Application No: Y/55/25/HH

Site Address: Sunnymead North End Road Yapton BN18 0DL

Description of works: Roof extension to facilitate conversion of loft to habitable use, including an increase in ridge height and the installation of front and rear dormers.

Thank you for your internet representation made on 15th September 2025 which has been recorded as an objection with the comments as follows:

PROJECT NO. 646	DRAWING NO. 201	REV. A
---------------------------	---------------------------	------------------

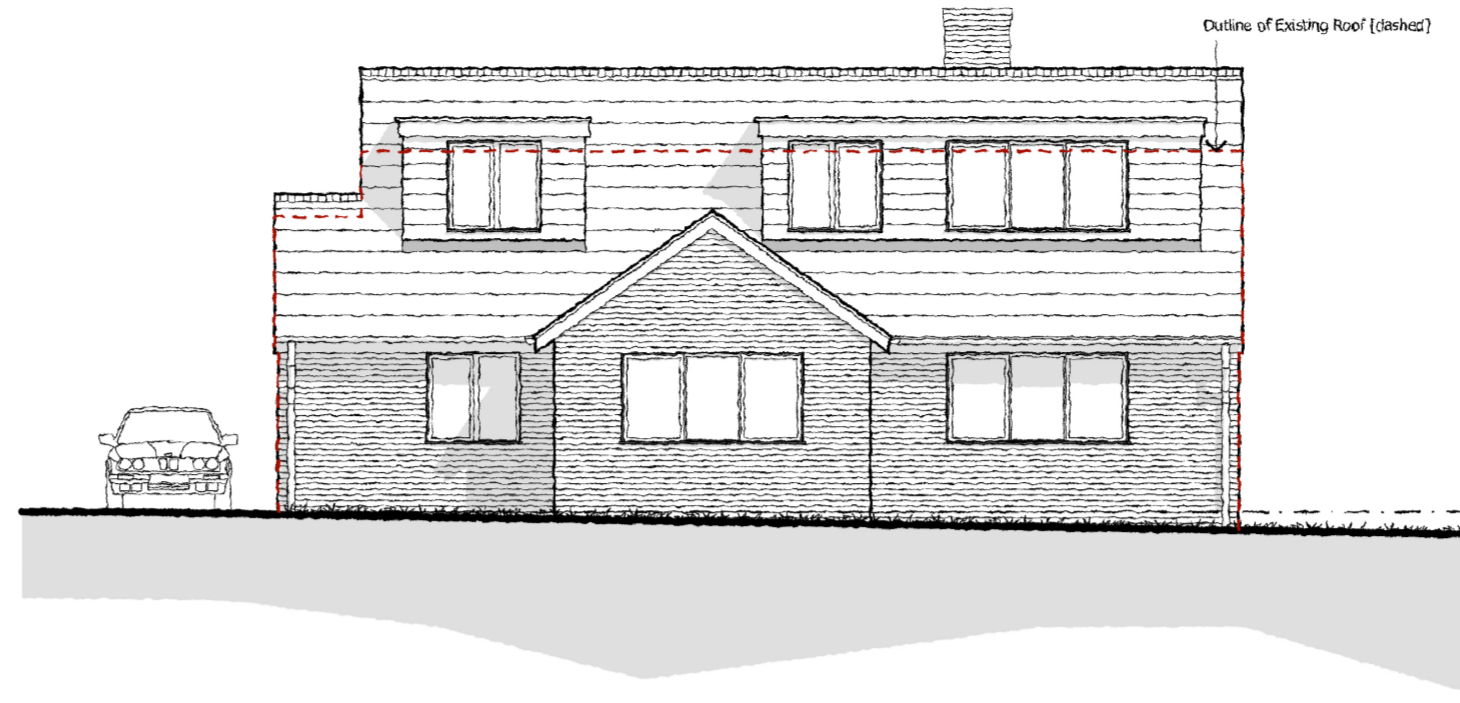
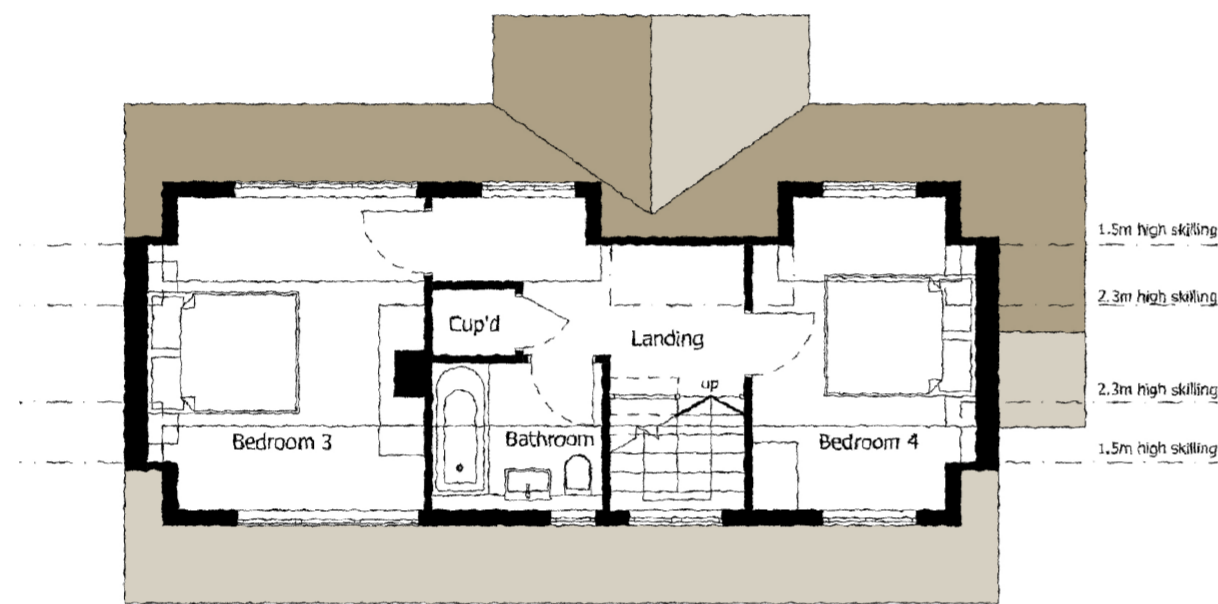
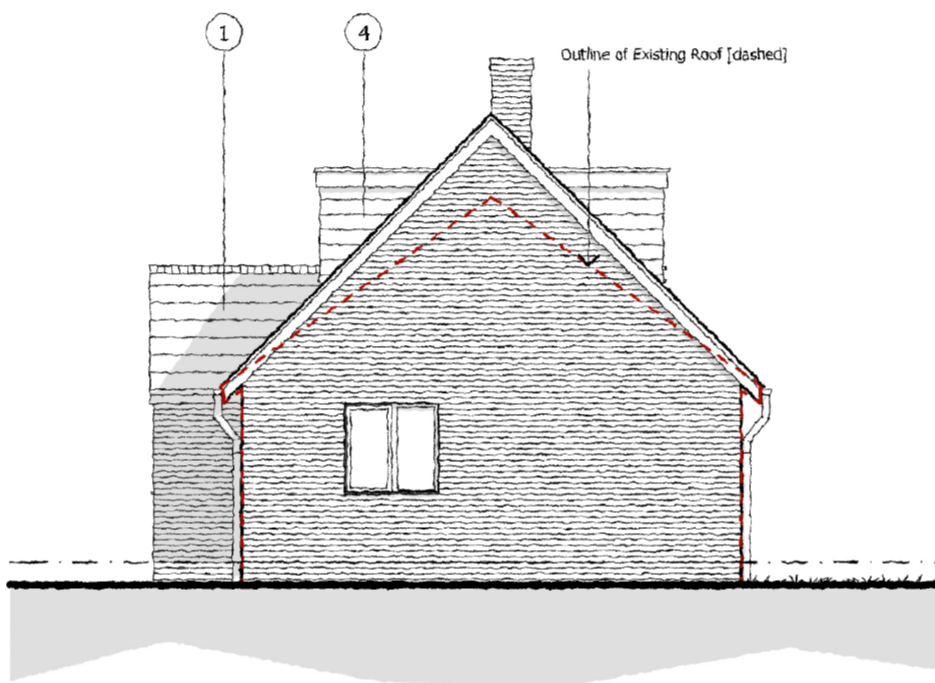
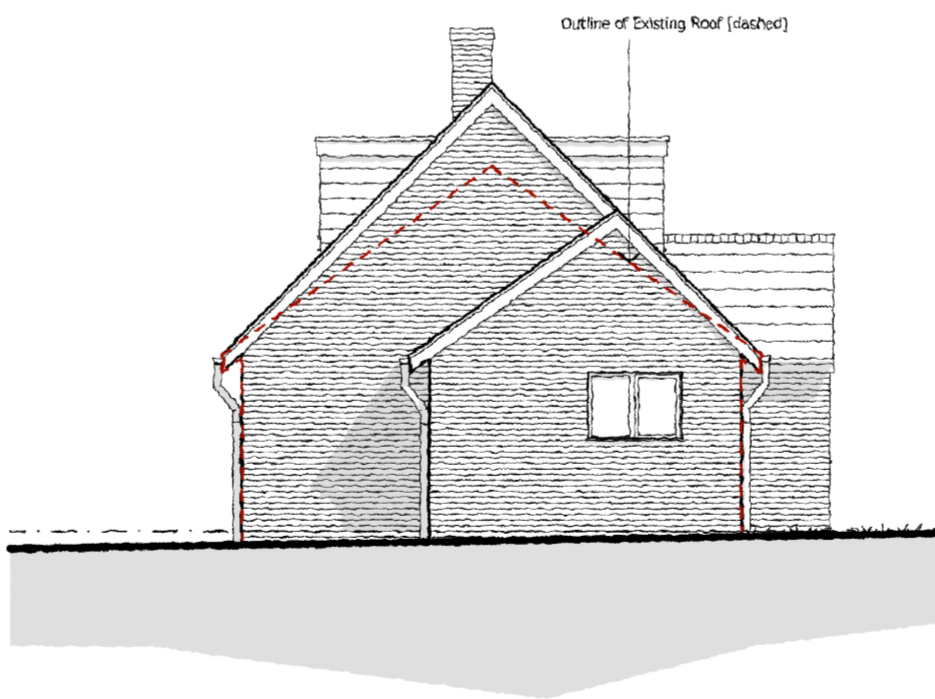
YPC insists that any extension proposal to the existing building clearly reflects the sensitive nature of the site and mirrors similar vernacular as its immediate adjacent dwellings. YPC would therefore seek individual dormer windows to reflect those opposite and the few along West Bank. This would be in-keeping with the YNP2 Design Guide. YPC therefore require more detailed information to enable it to make a fully informed response.
